From: Stephen Gee [REDACTED]
Sent: 14 February 2019 14:11
To: Simon Davis
Cc: Planning.Responses
Subject: RE: Application Y/103/18/PL Crematorium Proposal, Grevatts Lane West

It is noted that the applicant has revised the access proposals and access onto the A259 however the only indication of this I have is the low quality drawings provided at the end of the safety audit.

PBA drawing 128.001.007 Rev D

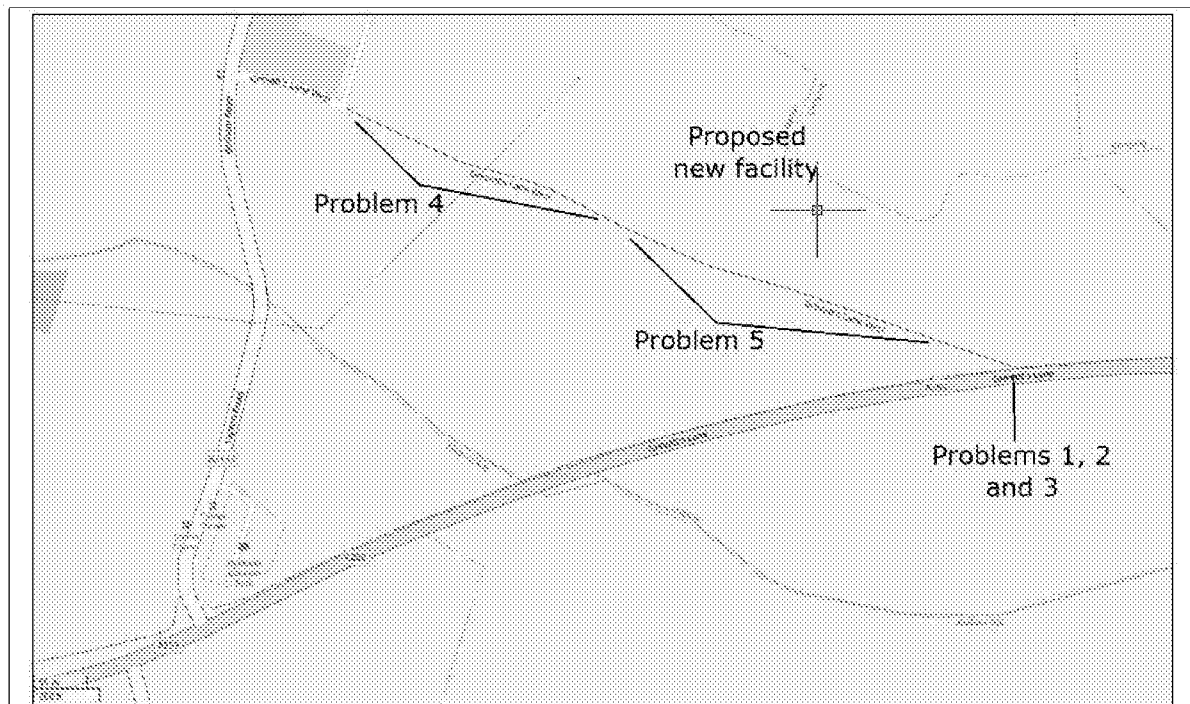
These plans should be submitted. I would also highlight the requirement for additional information from my initial response (replicated below)
